From: Martyn White <Martyn.White@arun.gov.uk>
Sent: 02 April 2020 13:48
To: Planning.Responses <Planning.Responses@arun.gov.uk>
Cc: Simon Davis <Simon.Davis@arun.gov.uk>
Subject: BR/282/19/PL

BR/282/19/PL

The property is located within The Steyne and Waterloo Square Conservation Area. A description of the conservation areas is provided in a Supplementary Planning Guidance Note. It is not repeated here. However, the contents of that description should also be taken into consideration as part of the determination of this application.

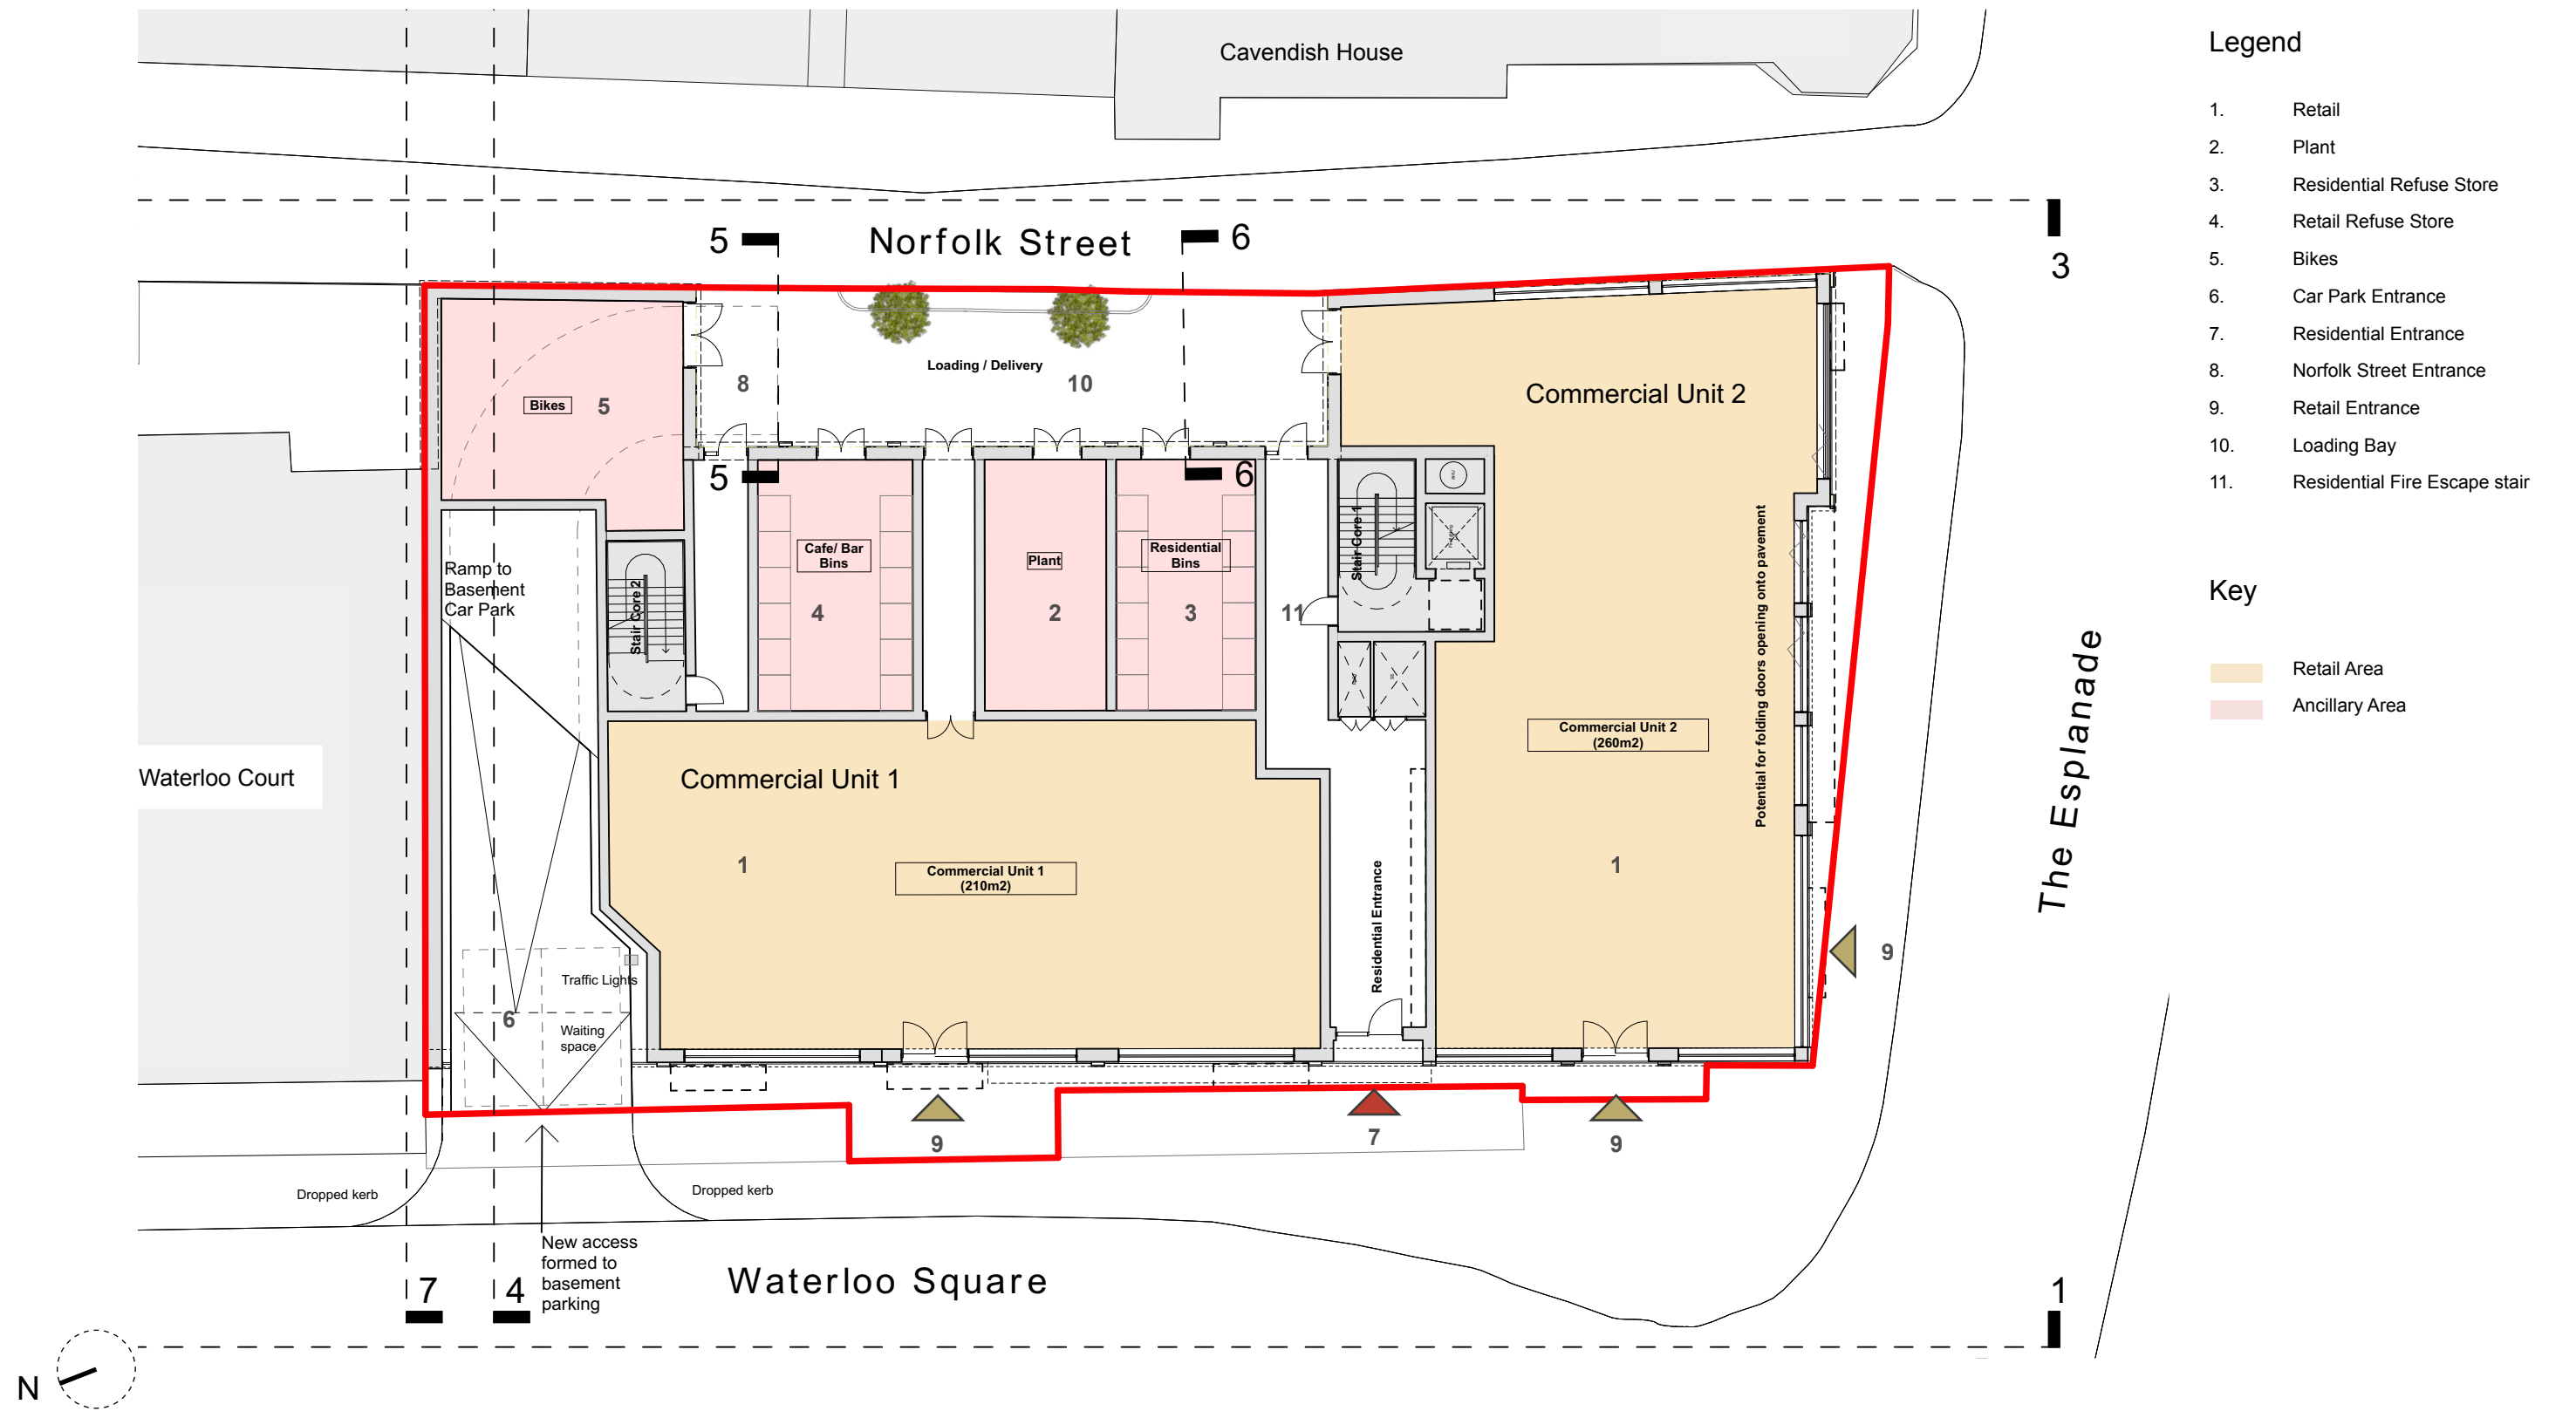
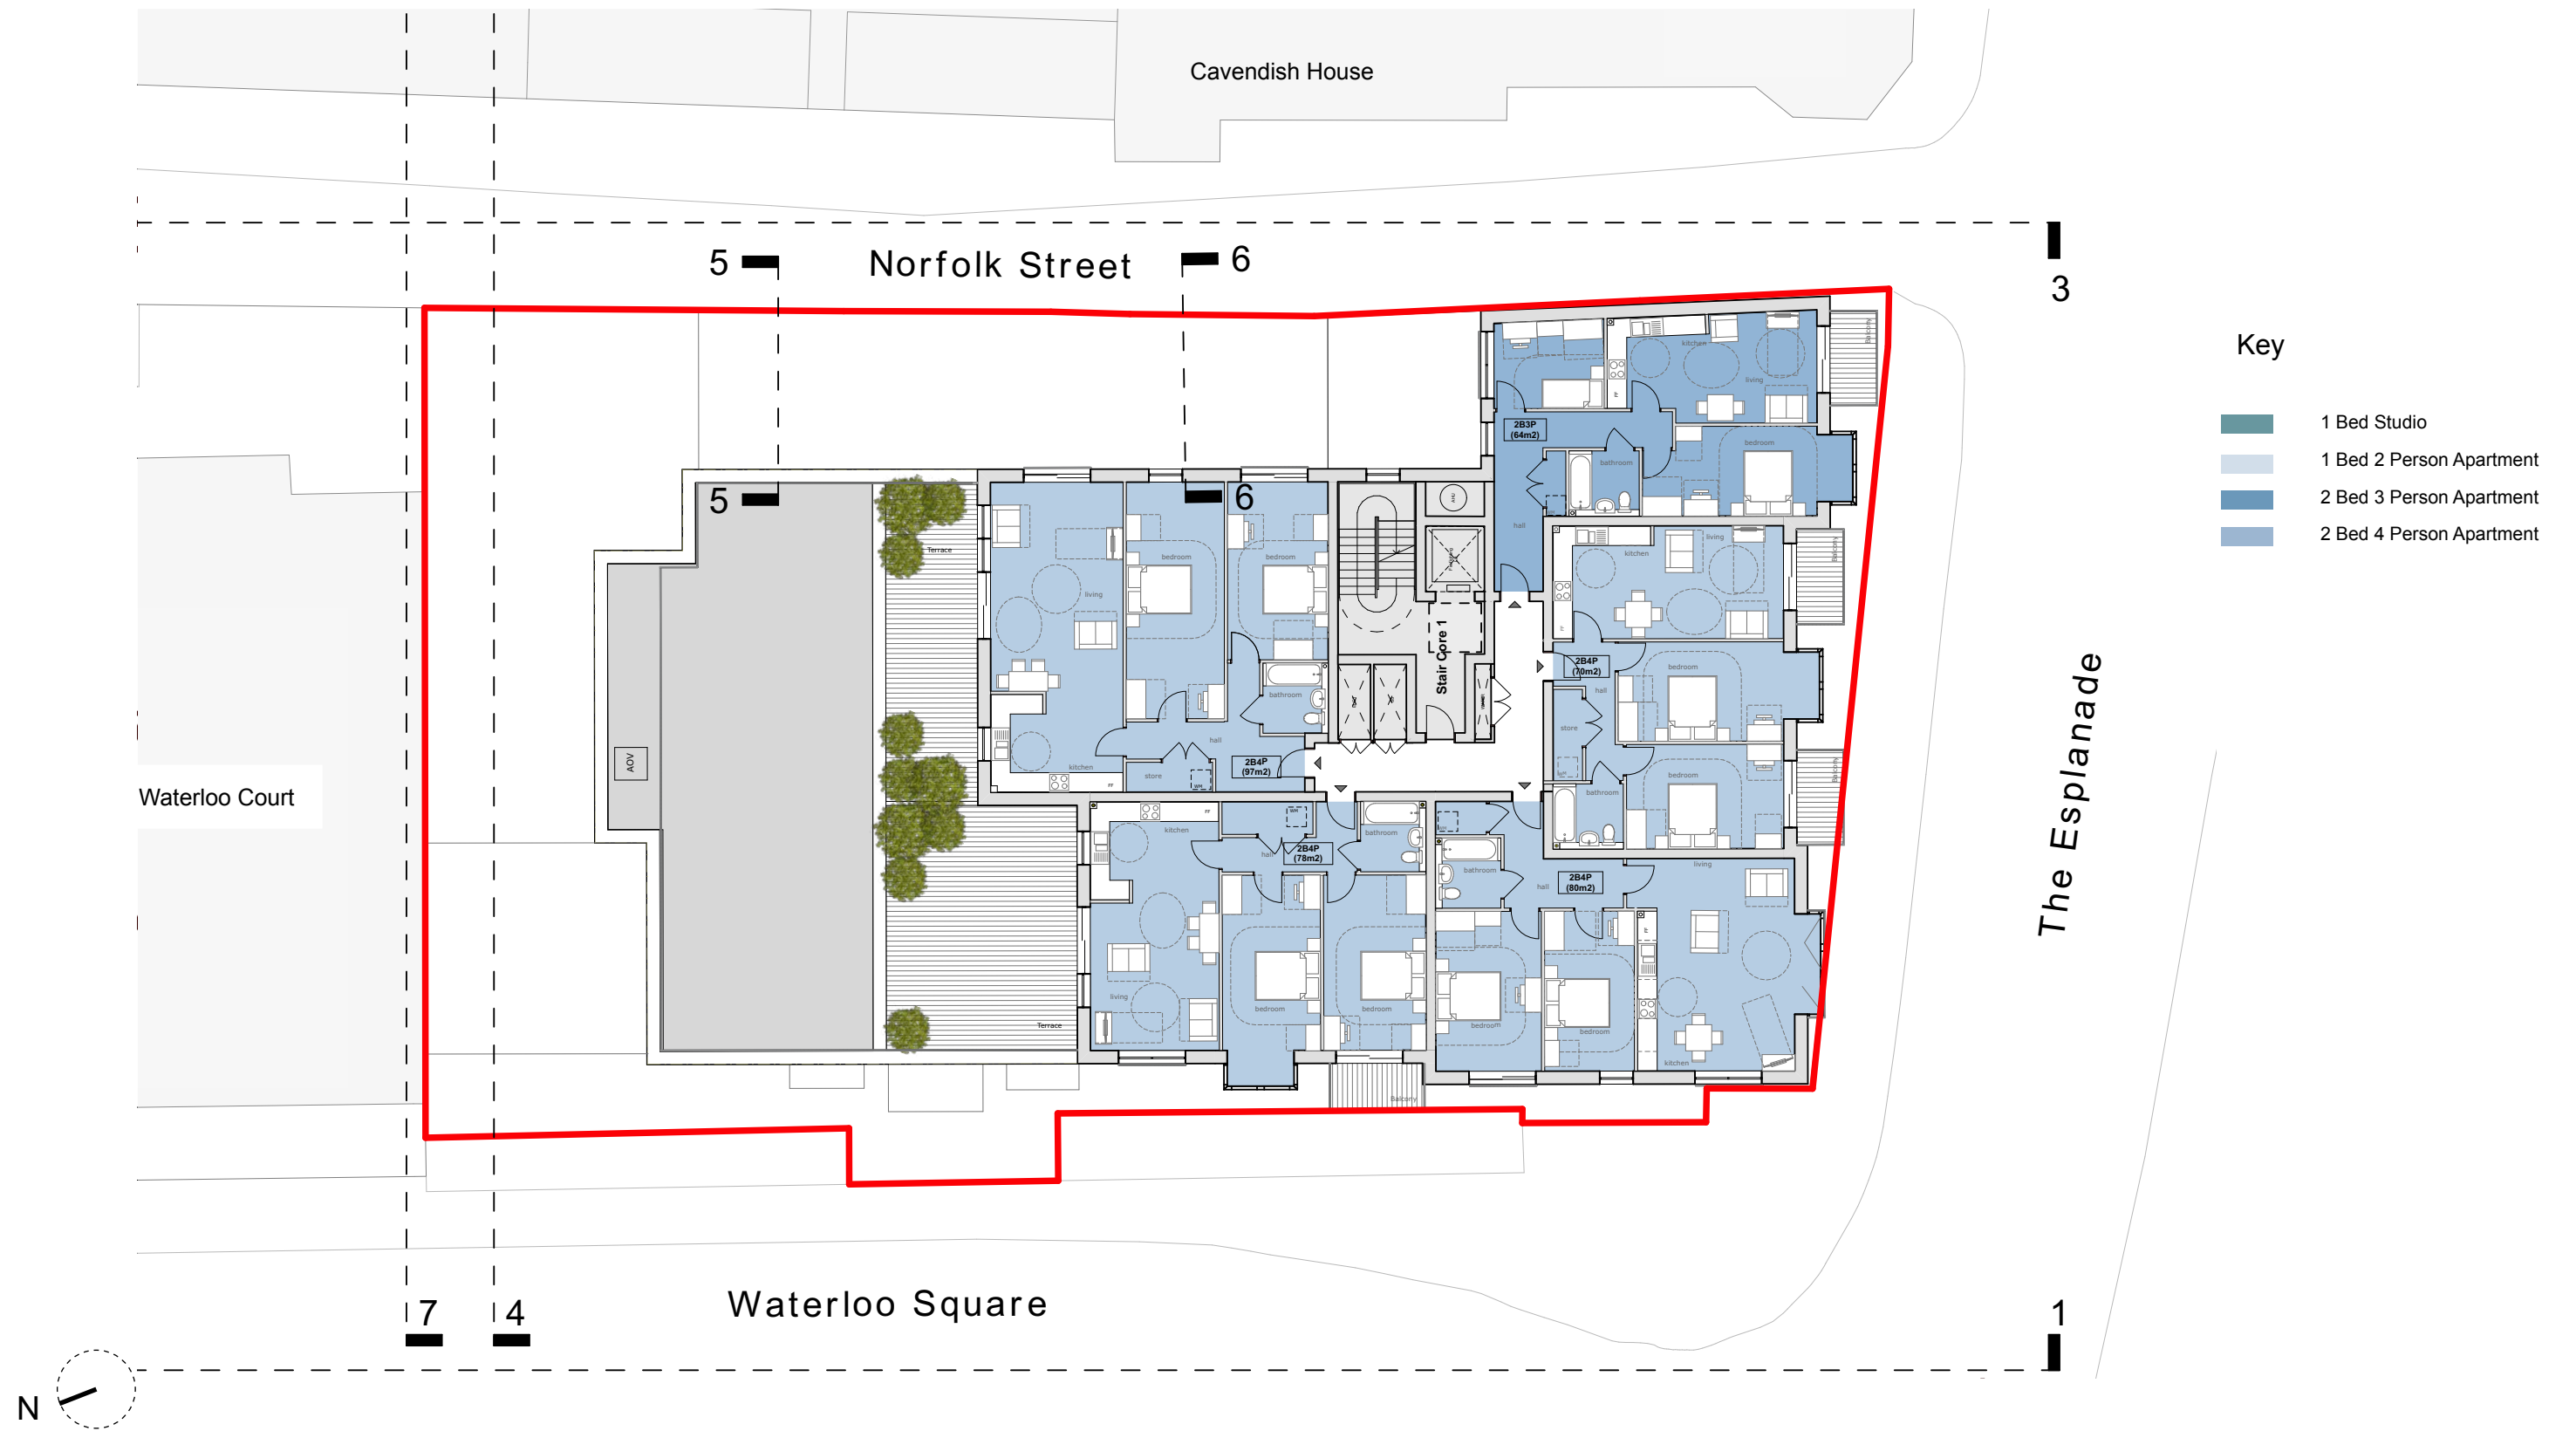
However, whilst some positive elements can be identified for the scheme, it is also considered that some elements of the proposal are problematical, most notably the height/massing of the building. The proposal, at up to 7 floors high, is double the tallest structure in this part of the conservation area, or in fact, the previous (now demolished) building on the application site. It would dominate the existing neighbouring buildings (especially in Waterloo Square).

It is also apparent from reviewing the proposed elevations, that whilst the new building attempts to integrate with neighbouring buildings in the square, there remains a significant variation in height from 7 to 3 floors. Such a large difference in height gives the impression of dwarfing the neighbouring buildings.

Additionally, it is worth noting that the proposed scheme (of one larger building) represents the replacement of three different buildings that maintained the proportion of other property frontages within the Square, whilst also complementing the mix of styles within the conservation area.

Consequently, it is considered that the proposal will have a negative impact on the character of the conservation area and surrounding heritage assets.
